Proposal: EN0110001 Keadby Next Generation Power Station Project.

Canal & River Trust Response Submission for Deadline One (interested Party Number: [REDACTED])

### Summary of Oral Submissions Made at Issue Specific Hearing 1 (ISH1) (21/01/2026)

Indicative Workboat Location - Keadby  
& Stainforth Canal

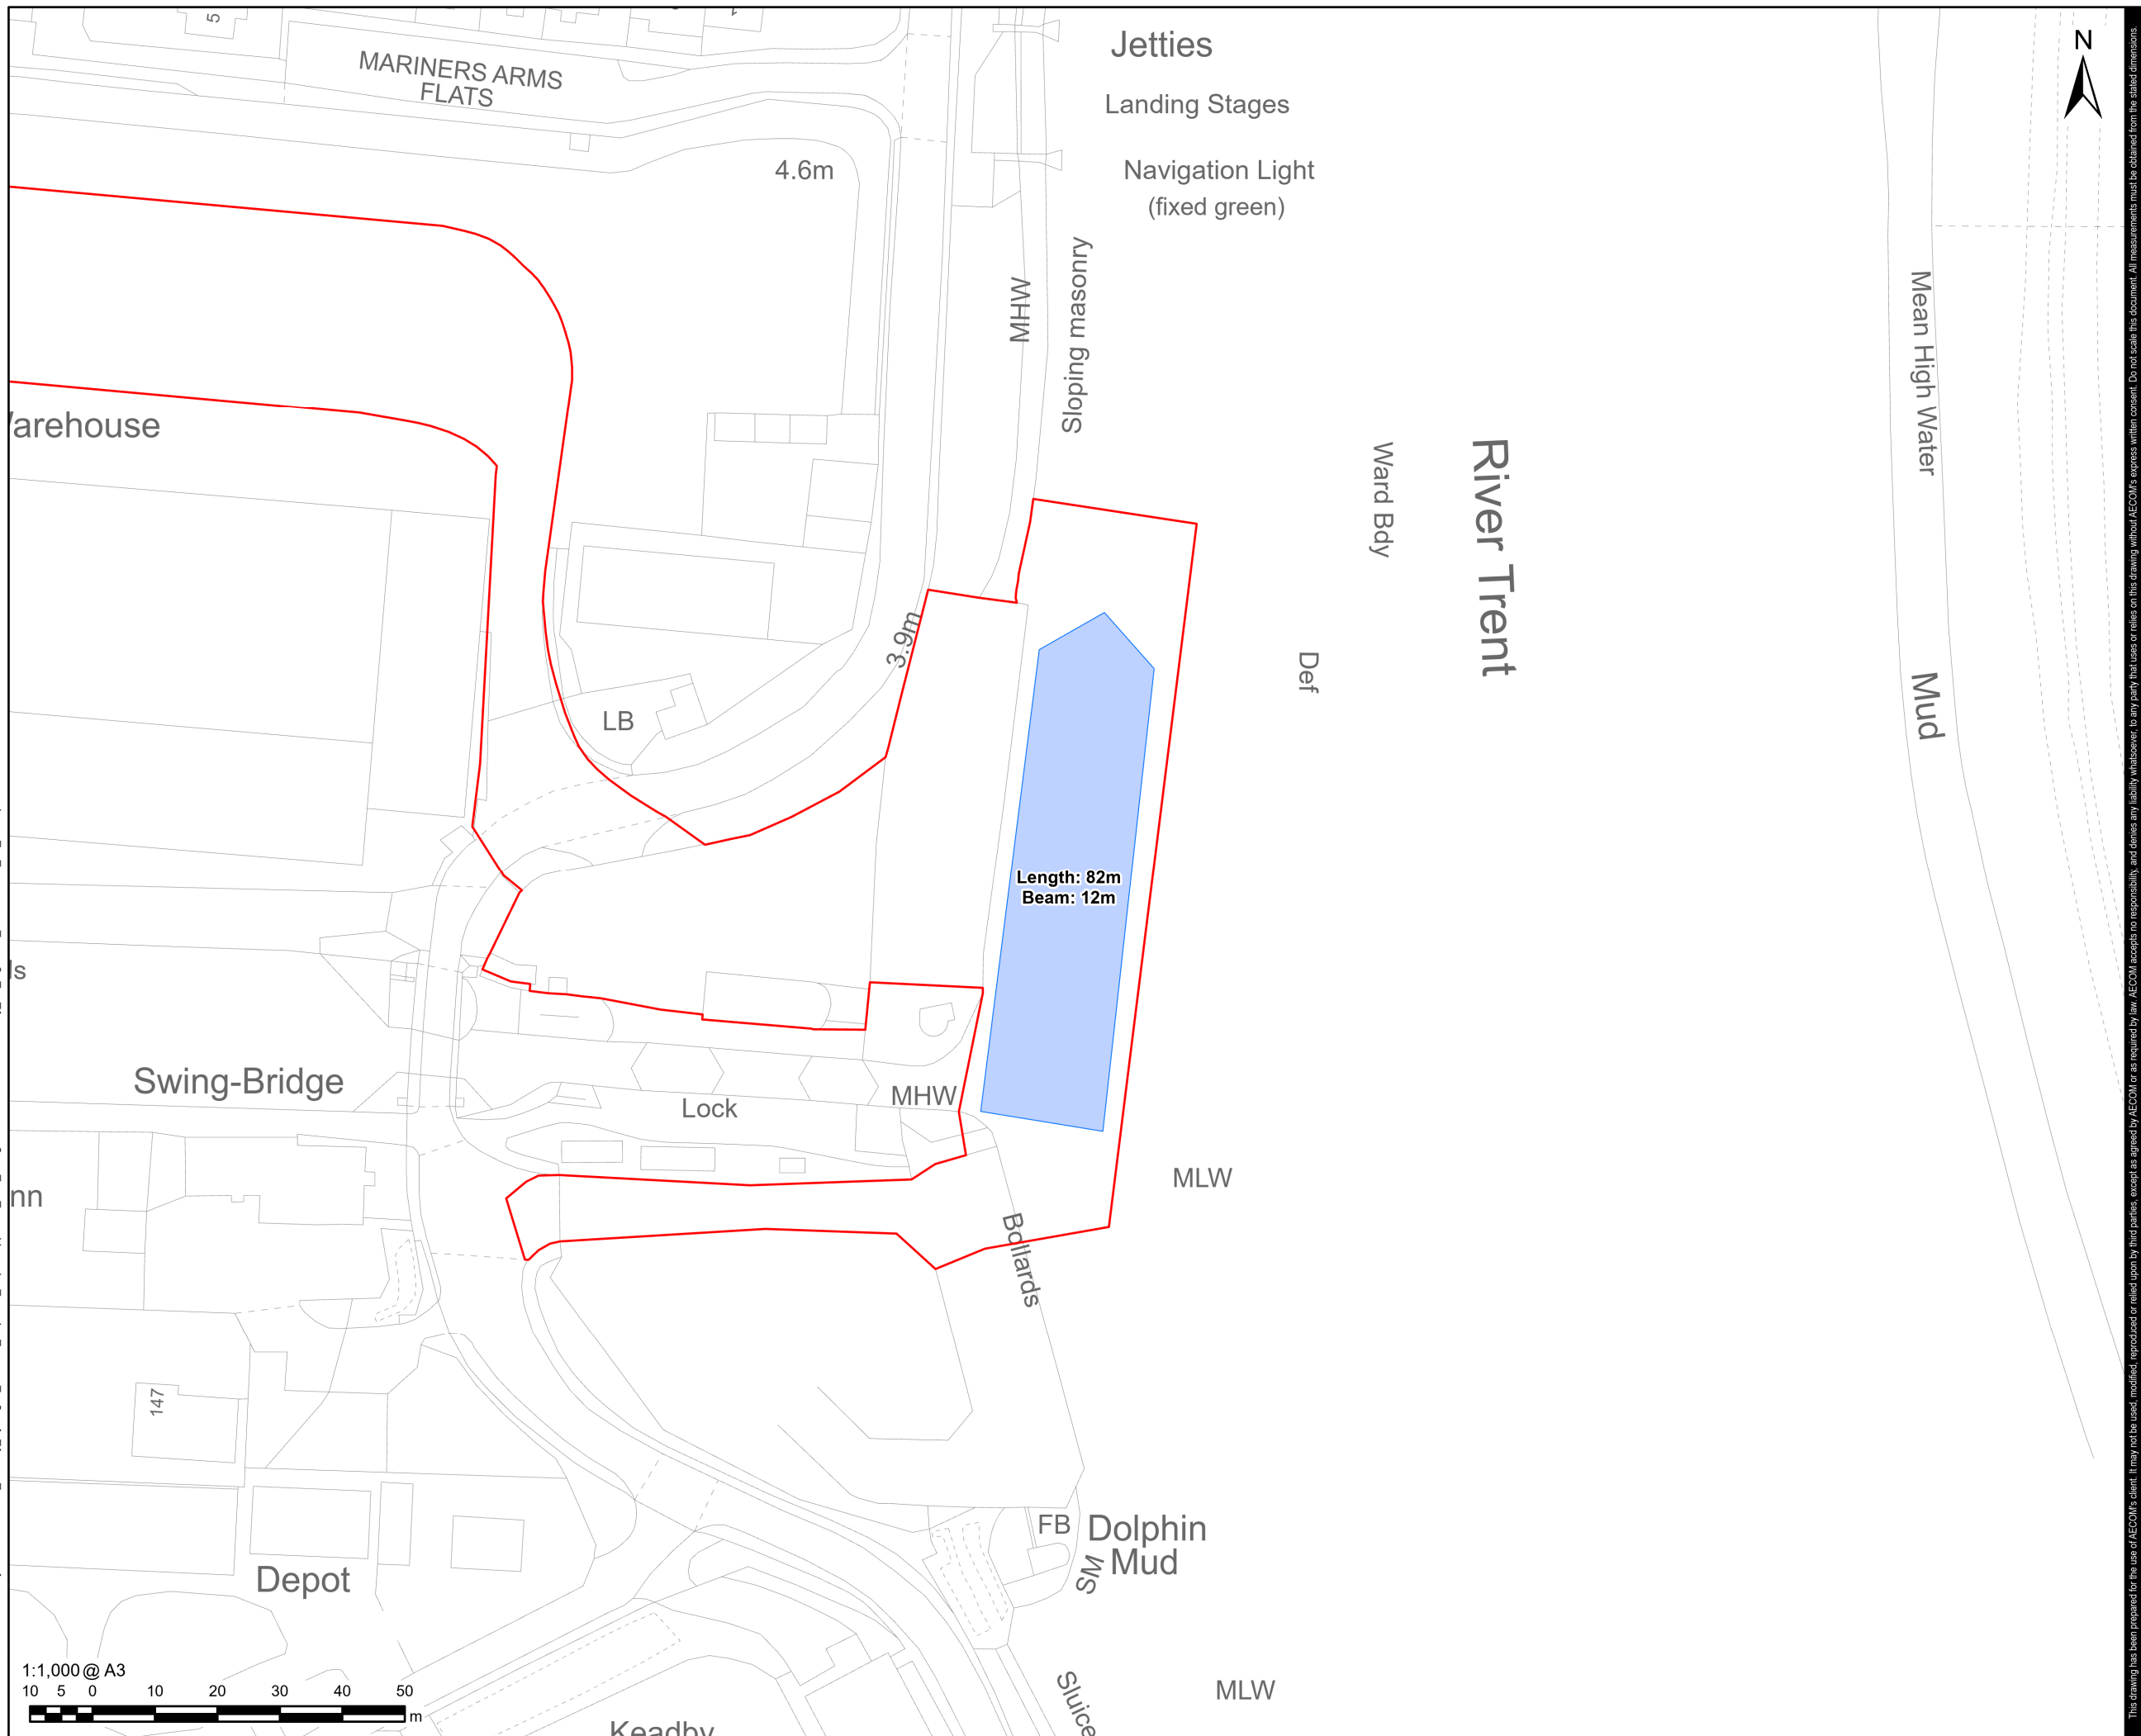
1. The Trust made comment with respect to the wording within the Construction and Environmental Management Plan (CEMP) (APP-166) which states that the works to construct a temporary cofferdam will involve works extending 20m into the Stainforth & Keadby Canal (e.g. paragraph 5.4.35).

2. A 20m projection would restrict the available navigation width to the south to approximately 10m, which would be insufficient to allow for the safe passage of vessels during the works. We are concerned that this would result in the effective closure of the canal for indefinite periods of time during the works, which would cause disruption to boat users and is not in line with our statutory duties to maintain the waterway for commercial use.

3. We highlighted that the outfall for the completed Keadby 2 development was constructed with a cofferdam extending only 10m from the north bank, and that the Keadby 3 Project was approved also with a 10m

cofferdam. Due to the similarities between the projects, we consider that a cofferdam projecting 10m, as opposed to 20m, could be feasible, and would overcome our concern.

Plate 2: Abnormal Indivisible Load Route via Waterborne Transport Offloading Area for Proposed Development

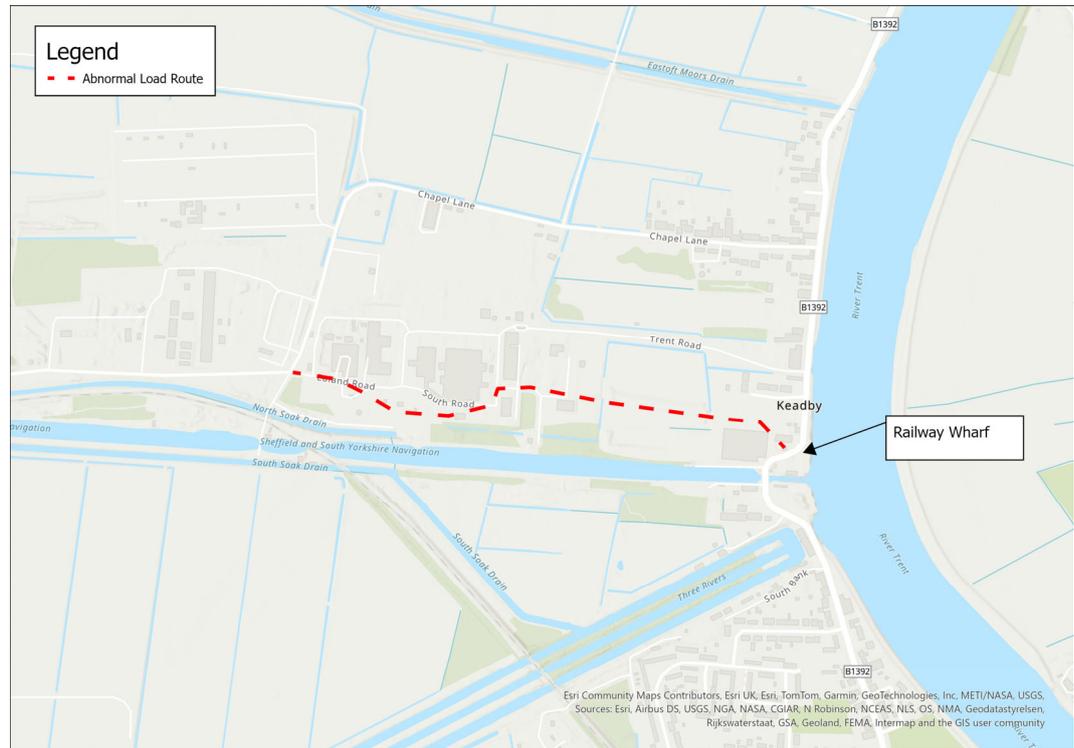
7. The Trust highlighted that the proposals intend to utilise Railway Wharf for the delivery of Abnormal Indivisible Loads to the site.
8. Large vessel using the wharf can result in obstructions to Keadby Lock. We highlighted a concern that the CEMP (APP-166) states that notices to Mariners ('Notices and Stoppages') will be requested through the Canal & River Trust to inform boats of closure times. During previous use of the Wharf for the Keadby 2 project, vessels would often arrive outside of previously agreed times, for example due to their voyages taking longer or shorter than expected, providing limited additional notice of their arrival. This poses a safety risk for boaters wishing to access the lock from the River Trent, as without sufficient notice, these craft could become stranded on the on the river as it is tidal and some vessels can only navigate safely on tidal rivers at specific times.

9. We raised a concern that this matter was not assessed in the Navigational Risk Assessment (APP-075). We note the applicant claimed differently at the hearing. Our comment related to whether the Assessment refers to ALL deliveries at Railway Wharf, and whether it specifically refers to the danger of vessels being stranded on a tidal river should vessels blocking access to Keadby Lock arrive at short notice, outside of prior agreed times. Prior notification of times did not, for the Keadby 2 scheme, previously prevent unplanned closures.

10. Although the Trust note that the applicant seeks to provide a Wharf Management Plan, reserved as a requirement in the draft DCO, we do have concern that principles of procedures to prevent and/or minimise unplanned obstructions to Keadby Lock should be identified beforehand. This is to prevent a circumstance arising where an acceptable solution cannot be identified when it comes to discharging the requirement. This could be achieved through agreement with the Trust of an Outline Wharf Management Plan that identifies key principles that will be adopted to prevent unplanned closures of the Lock at short notice.
